Town & Country Planning Act 1990 (as amended)
Town & country Planning (Development Management Procedure) (England) Order 2015
Application for Planning Permission for Works or Extension to a Dwelling

Development New porch with hip roof & brick dwarf wall, new detached garage, new window to west elevation,
new doors to south elevation, new sun tunnel for north elevation & improved drainage & low wall alteration.

Location Calceto Barn Calceto Lane Lyminster

PROPOSED ELEVATION
DATE: SEPTEMBER 2018
SCALE: 1:100 @ A3
JOB No. 1040
DRWG No. 108 - Rev.

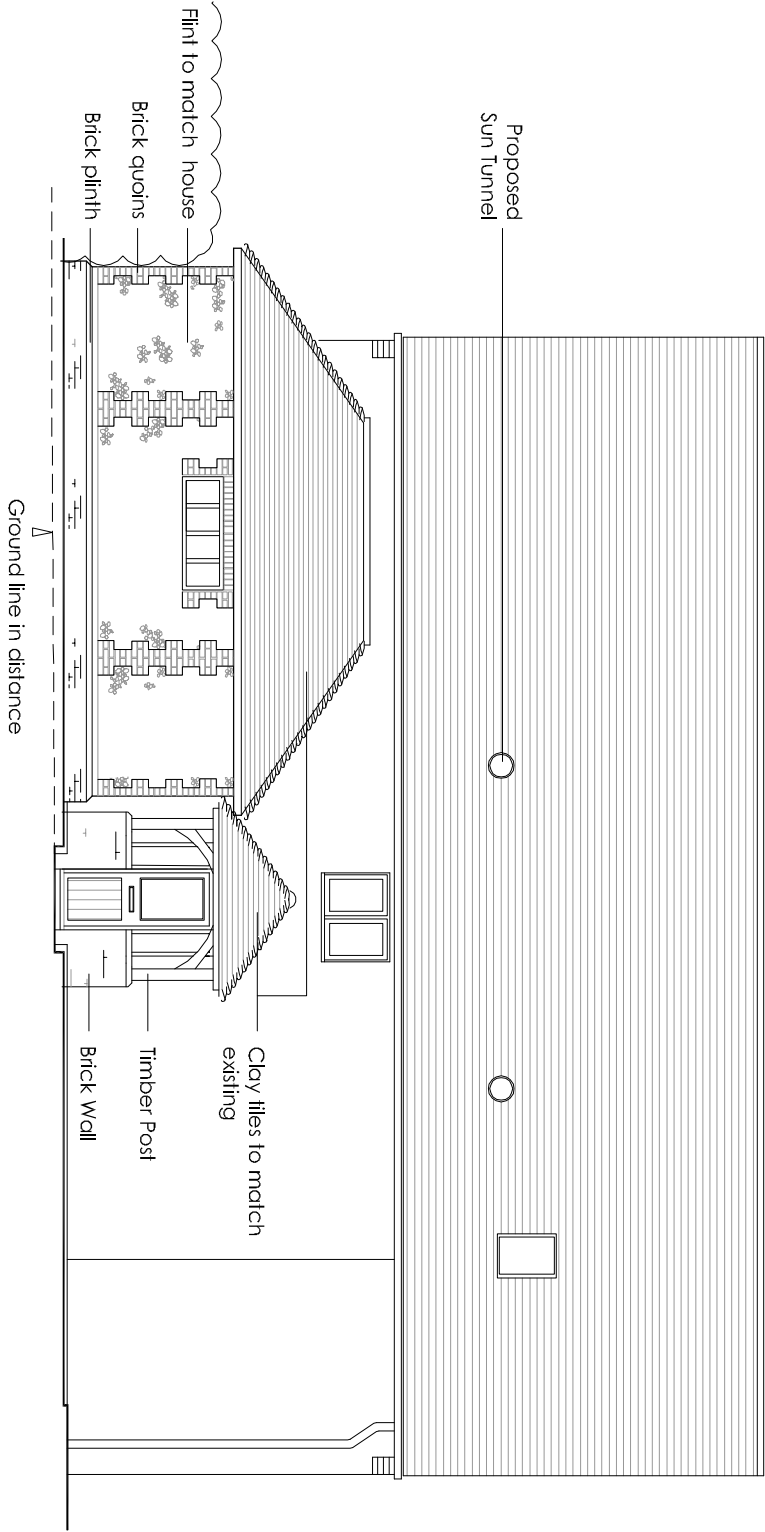
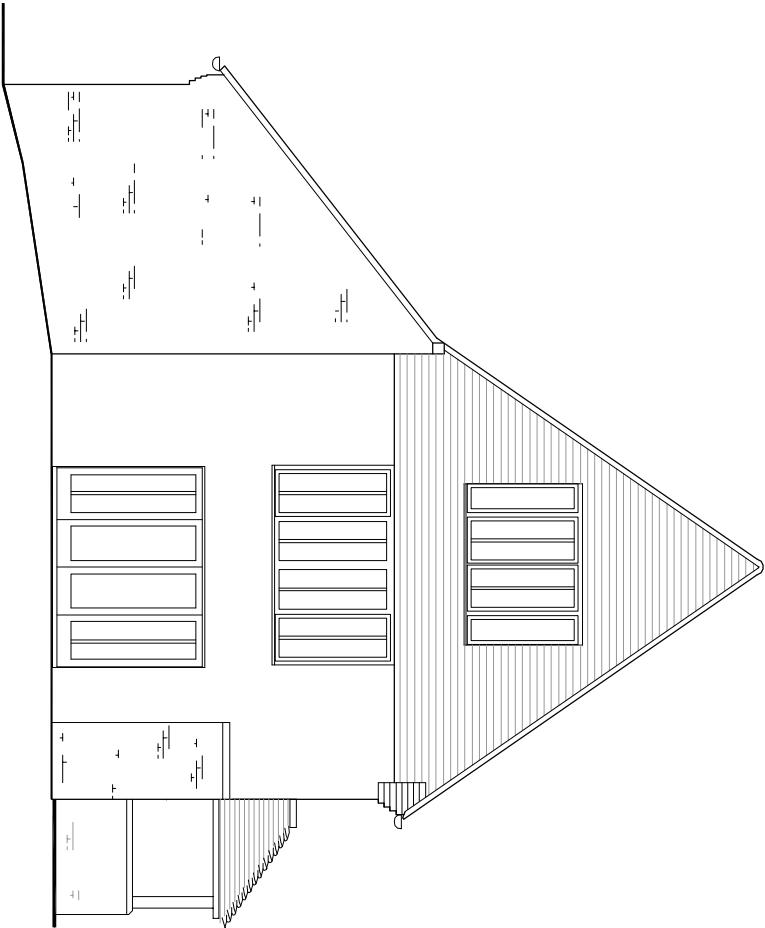
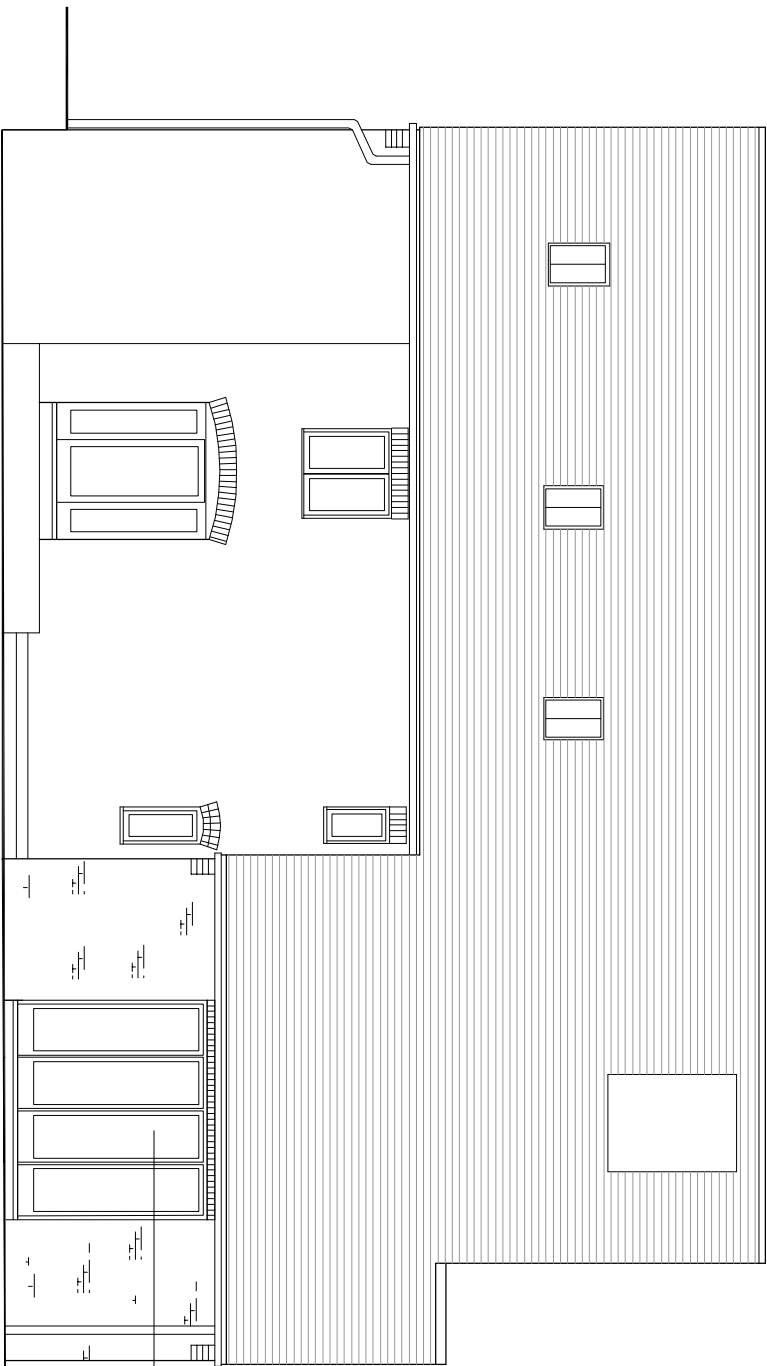
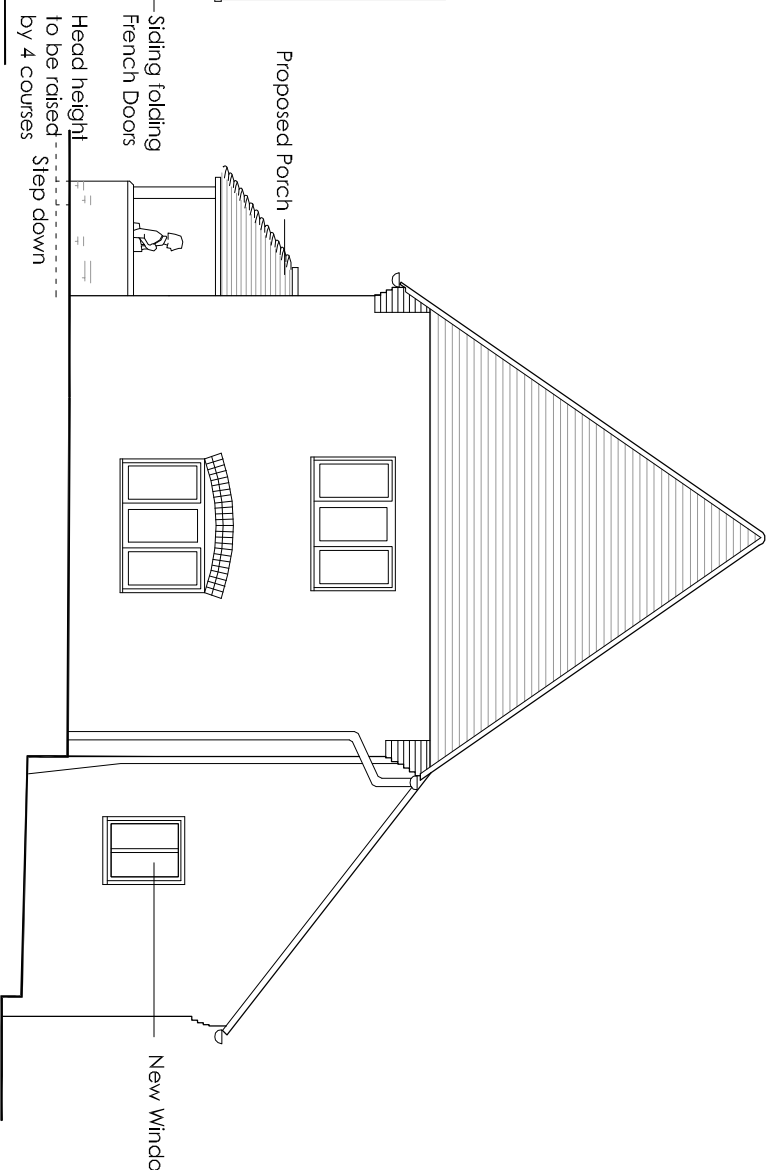
Please provide existing and proposed East elevations (two north elevations have been provided, which one has been mislabelled).
